CITY OF ALBUQUERQUE

**Re: Juan Tabo Hills Unit 3B
Engineer's Stamp Date 4-14-14 (M22D016B)
Certification dated 2-9-15**

Based upon the information provided in your submittal received 2-10-15,
Hydrology has the following comments:

EXISTING A.M.A.F.C.A. FLOODPLAIN EASEMENT

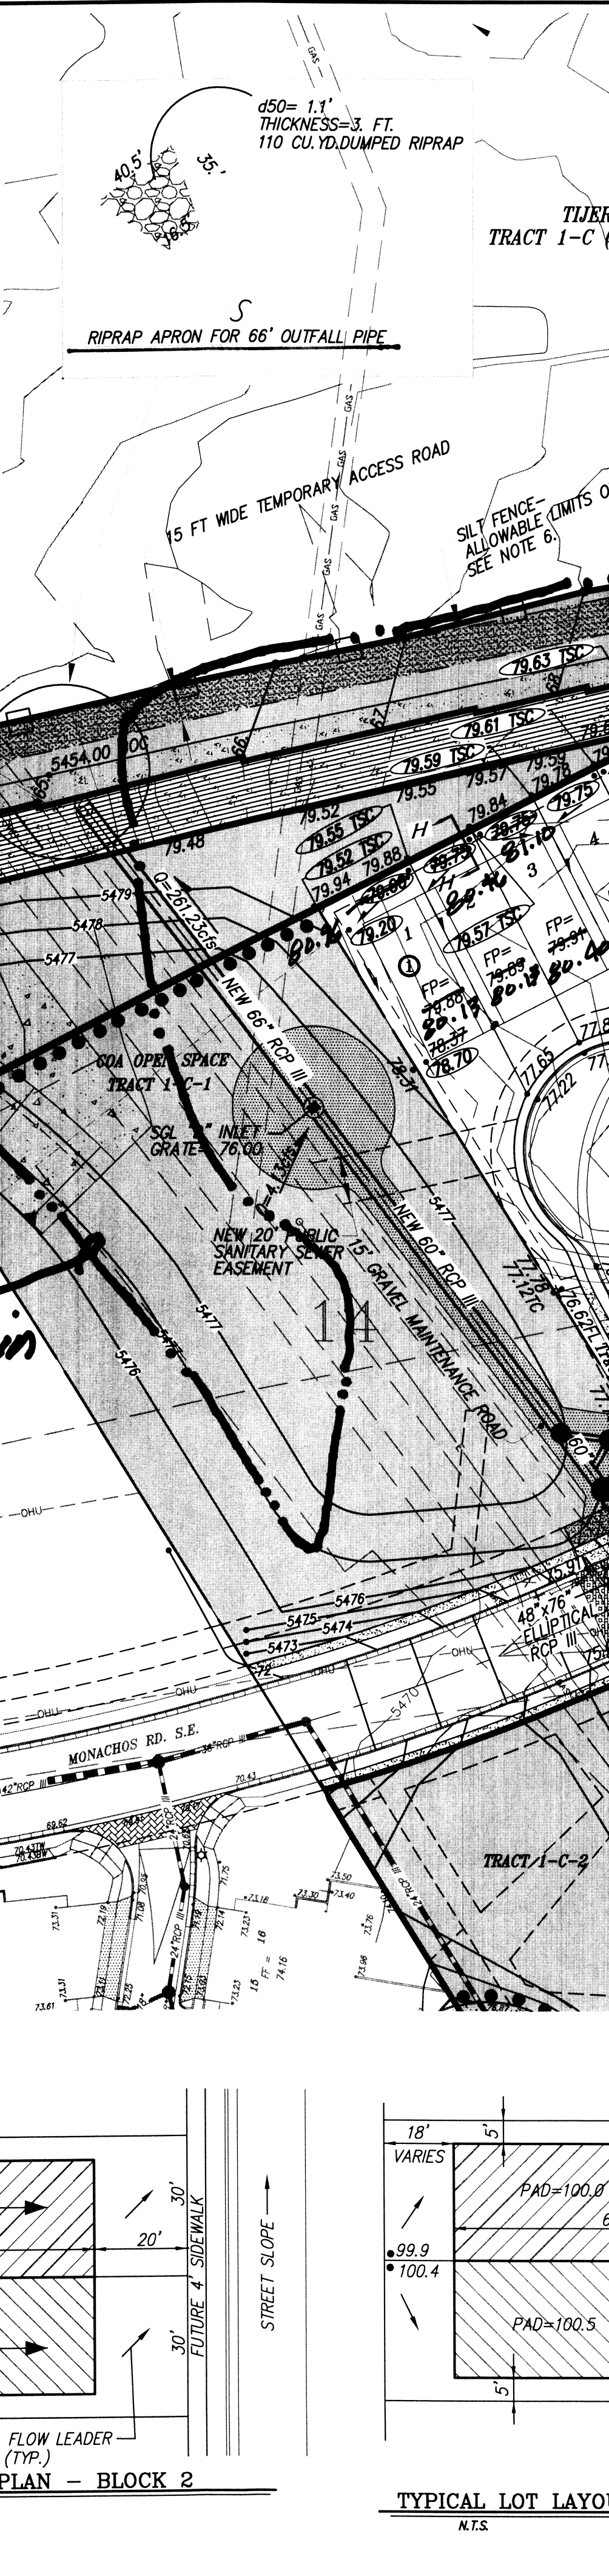
1. The grading of the site is acceptable; except for the swale between lots 3 and 4 is directed towards the electrical box and other dry utility boxes. Should a small wall be constructed upstream of the boxes?

2. The boulders were not placed in Tract 1-C-1 as shown on the plan.
3. The dumped rip-rap pad downstream of the 66" storm drain is smaller than shown on the plan. If this is acceptable to AMAFCA, then it is acceptable to Hydrology.
